Location of Construction:		Owner:		Phone:		Permit No: <b>990404</b>	
Owner Address:		Lessee/Buyer's Name:		Phone:		Business Name:	
Contractor Name:		Address:		Phone:		Permit Issued:	
Past Use:		Proposed Use:		COST OF WORK: \$ 3,000.00		PERMIT FEE: \$ 445.00	
				FIRE DEPT. <input checked="" type="checkbox"/> Approved <input type="checkbox"/> Denied		INSPECTION: Use Group <b>R-1</b> Type: <b>50</b>	
Proposed Project Description: <i>interior renovation / 5 1/2 room</i>				Signature: _____		Signature: <i>BOCA 96</i>	
				PEDESTRIAN ACTIVITIES DISTRICT (P.A.D.)		Zone: _____ CBL: _____	
				Action: Approved <input type="checkbox"/> Approved with Conditions: <input type="checkbox"/> Denied: <input type="checkbox"/>		Zoning Approval: <b>Special Zone or Reviews:</b> <input type="checkbox"/> Shoreland <input type="checkbox"/> Wetland <input type="checkbox"/> Flood Zone <input type="checkbox"/> Subdivision <input type="checkbox"/> Site Plan maj <input type="checkbox"/> minor <input type="checkbox"/> mm <input type="checkbox"/>

COMMENTS

Design for Fire Escape

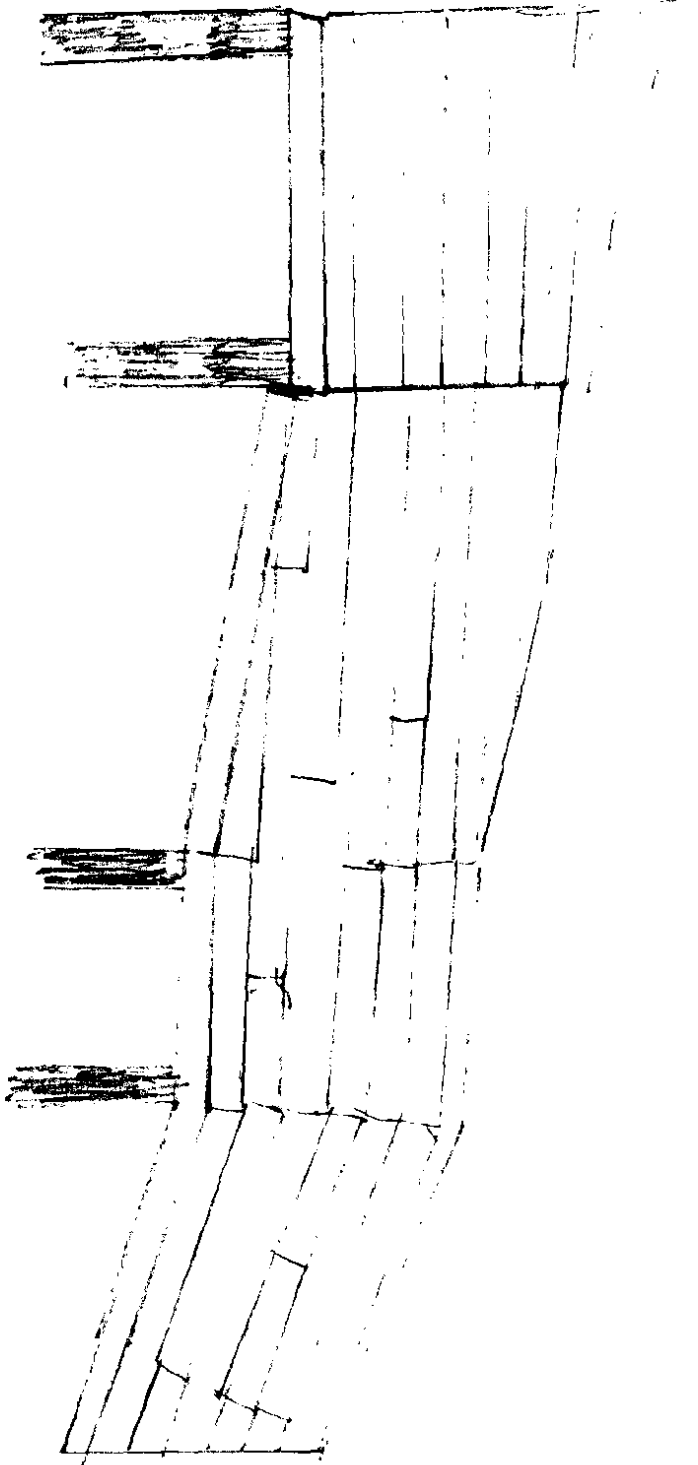
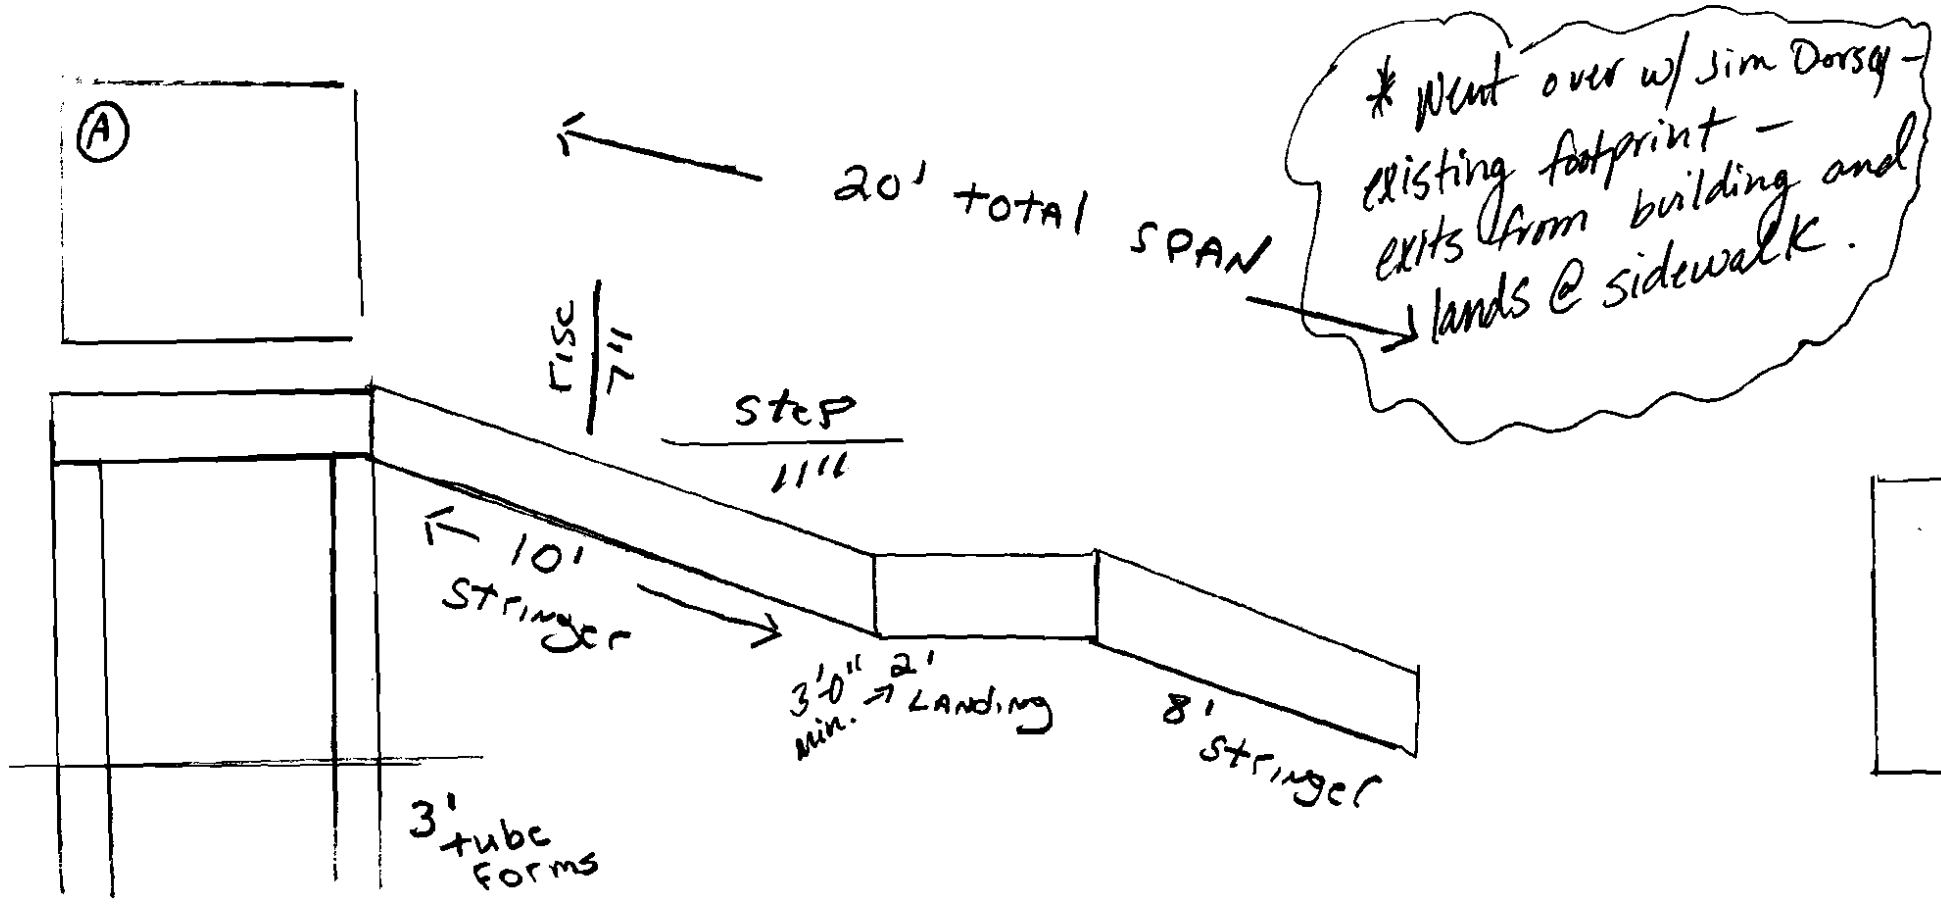
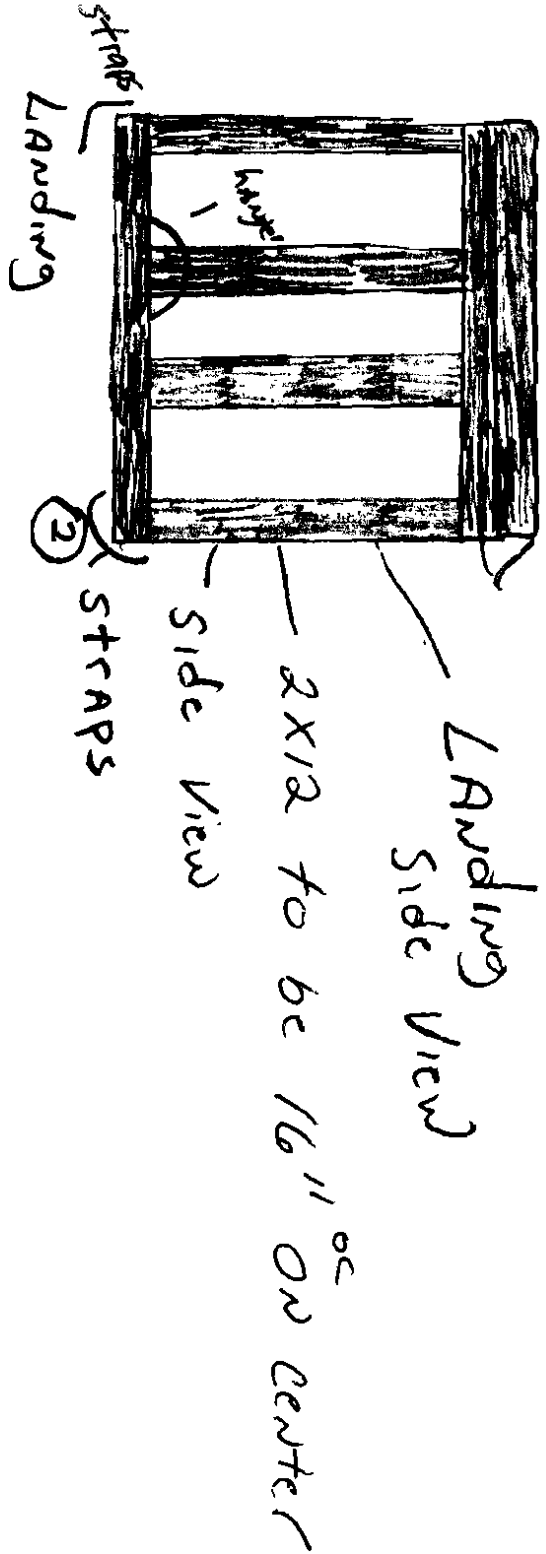
12/20/99 Checked for final inspection 5 new rooms - 2 Handicapped accessible - Everything in place - smokes OK, alarms OK, Rooms finished OK w/ Merland. Inspection  
Back stairs are new - no handrail / Treads have 7-11 w/ Raising (or raising) guardrail top low (25") must be raised. NO permit or plans submitted - need permit. Inspection  
1/17/00 Contractor filed Inspection civil's issue Part of Dec.
